REQUEST

Current Zoning: O-2 (office) and B-1 (neighborhood business)
Proposed Zoning: NS (neighborhood services)

Approximately 0.45 acres located on the east side of The Plaza, north of Mimosa and south of Mecklenburg Avenue.

PLANNING STAFF REVIEW

Revised Site Plan 11.14.22

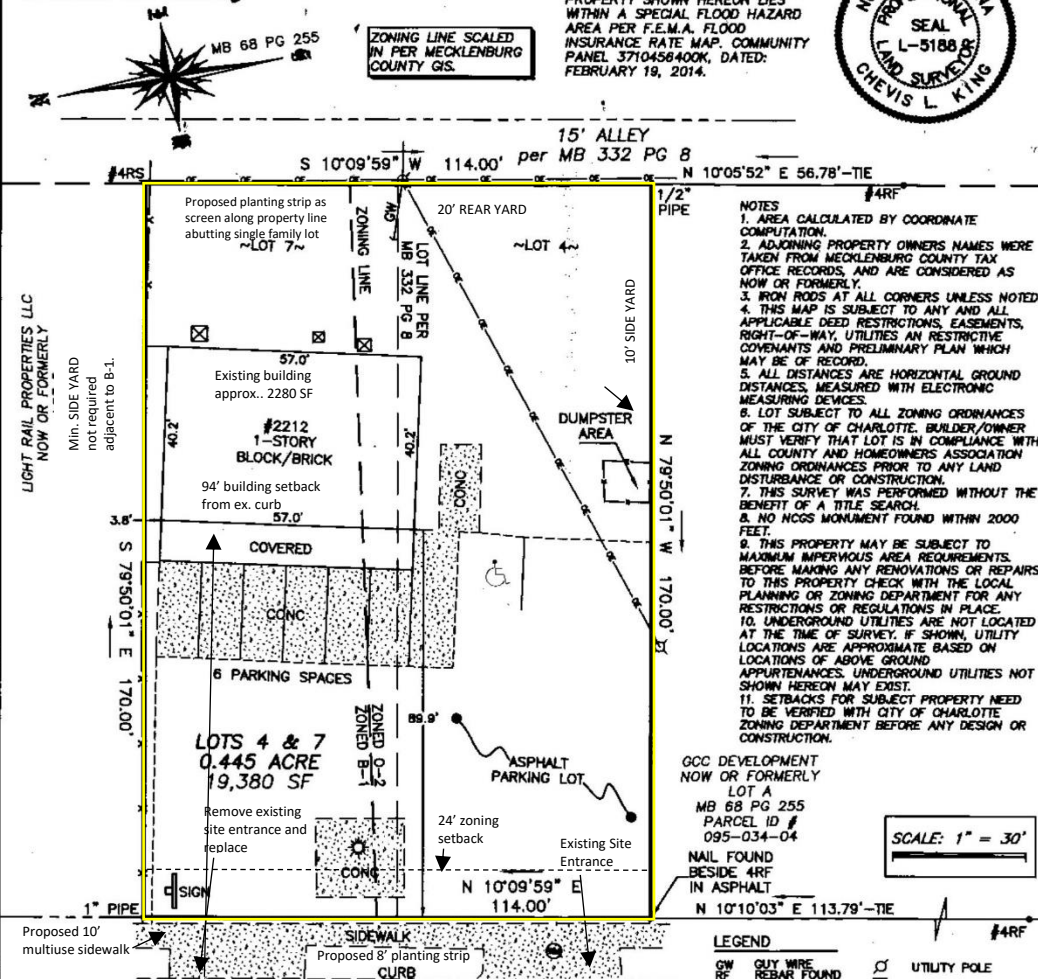
- 1. Remove "if needed" and "is needed" at the end of conditional notes shown below:

- Vehicular access to Site shall be via one of the current driveways as shown on the site plan
 - Close northern driveway
 - All improvements will be approved and constructed before the site's first building CO is issued **if needed**
 - commit to remarking current bike lane pavement markings to a dedicated right turn lane, a bike ramp near south property line per CLDSM 10.43 to transition bicyclists from separated bike lanes to multi-use path and extending the 10-foot multi-use path to the southern property.
 - Commit to striping and dedicated right turn arrow per CDOT pavement marking standards
 - commit to dedicating 50-feet of right-of-way if it does not currently exist.
 - fee simple conveyance of all rights-of-way to the City before the site's first building certificate of occupancy is issued **is needed**

- 2. All applications for grading, building, demolition, land use, change of use or rezoning permits on all property, except single-family development shall require a tree survey. The survey shall identify all trees of eight-inch dbh or greater and all planted trees of two-inch caliper or greater and six feet in height that grow partially or wholly within the city right-of-way.

3. Commit to providing a minimum 10-foot Class C buffer along property lines abutting residential zoning and/or use.
-
